**CENTRAL BEDFORDSHIRE COUNCIL COMMENTS ON DEADLINE 4
SUBMISSIONS**

LONDON LUTON AIRPORT EXPANSION DEVELOPMENT CONSENT ORDER

This document sets out the response of Central Bedfordshire Council (CBC) to various documents submitted at Deadline 4. The comments include input from various technical consultants.

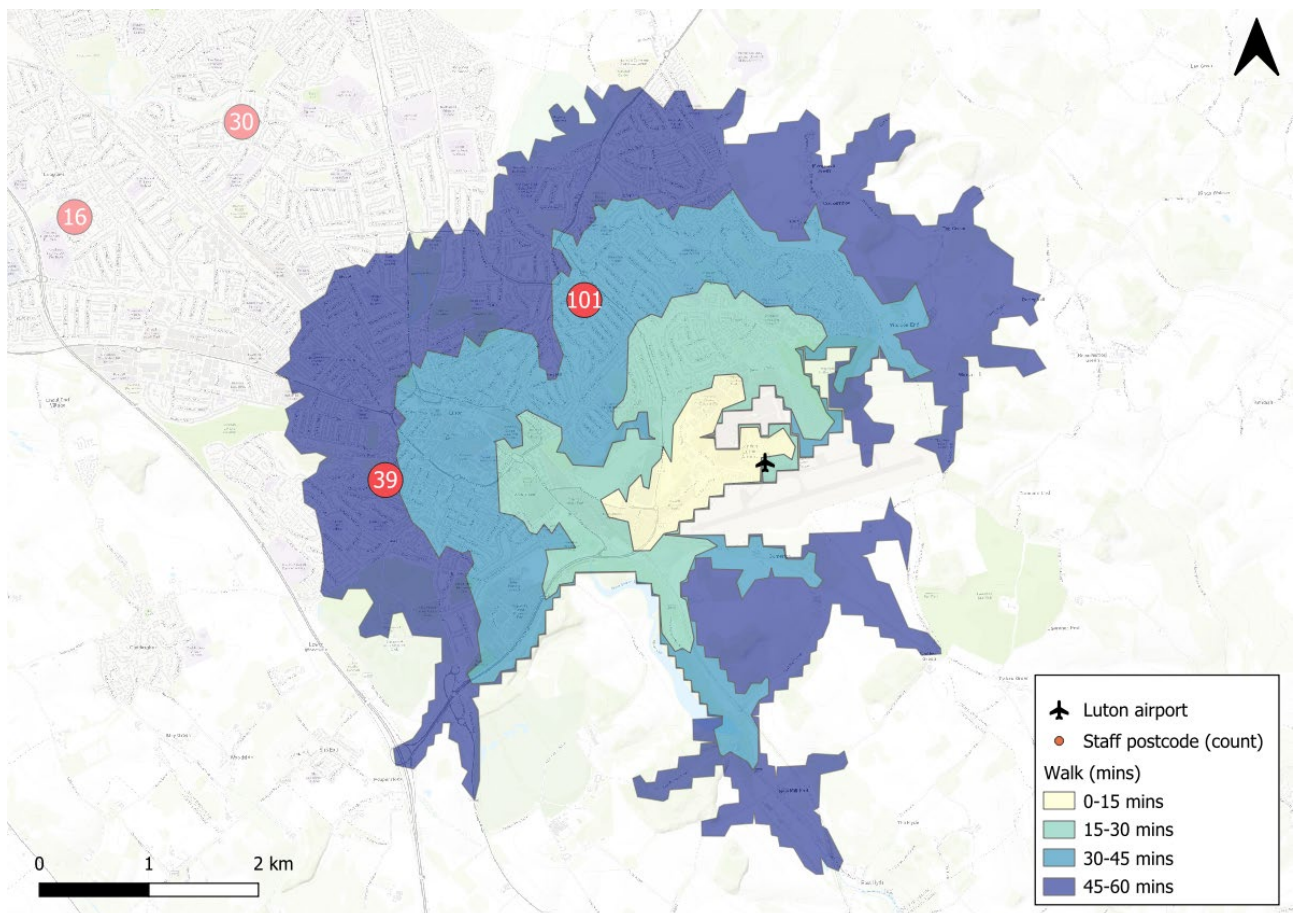
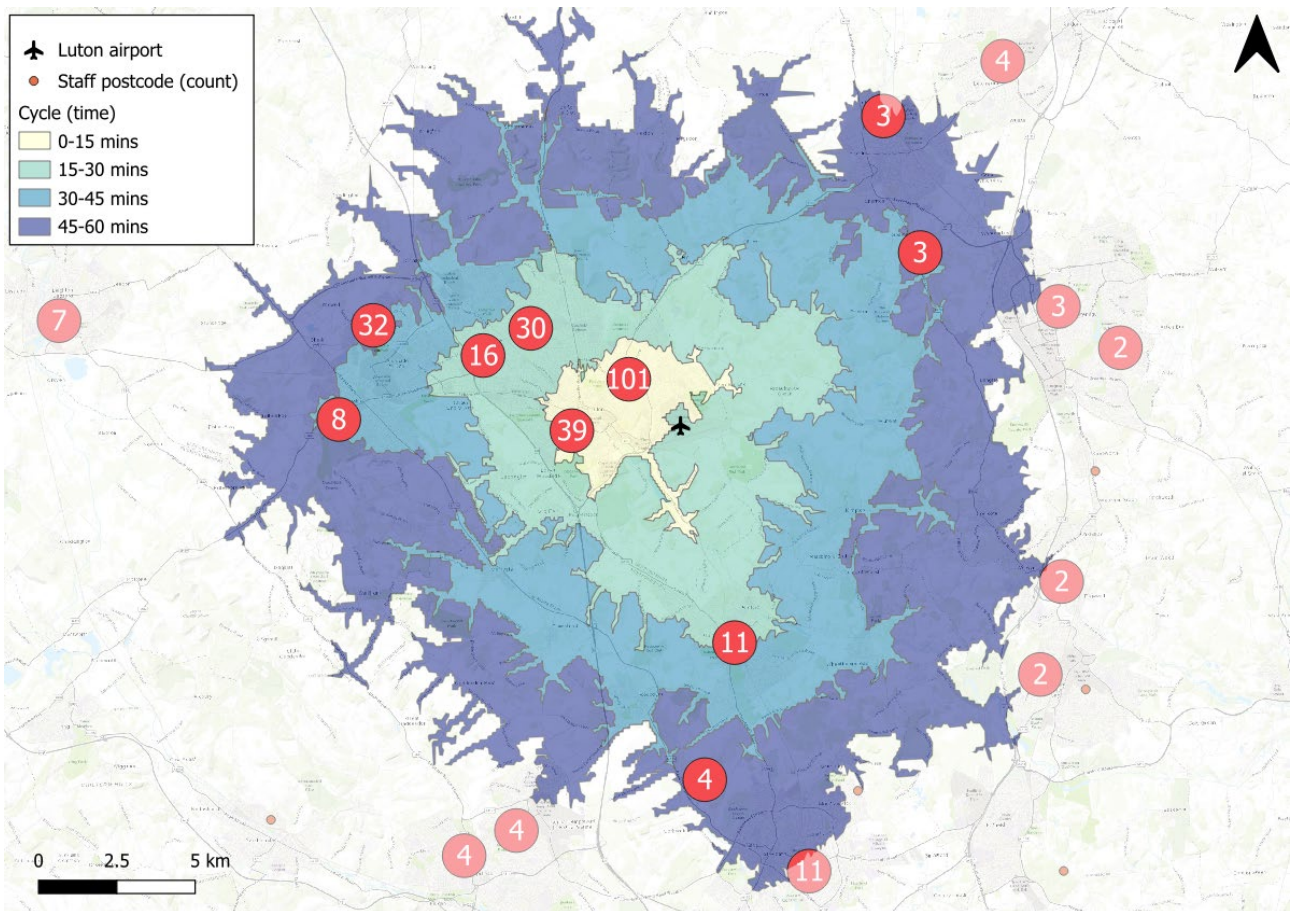
Whilst the majority of the measures to encourage staff to walk and cycle are likely to fall within the Luton Borough Council Authority area, there is a notable cluster of staff postcodes within the 30 - 45 minute banding provided as Figure 4.1, covering the Houghton Regis and Dunstable areas. This would generally appear to support the need for appropriate measures, whether based around cycling or public transport, to facilitate sustainable staff access to / from the Airport from these postcode areas. Whilst it is understood that it may be difficult to identify specific public transport routes, CBC would be seeking an acknowledgement of this demand and a commitment to include it within the measures to be reviewed through the Sustainable Transport Fund process.
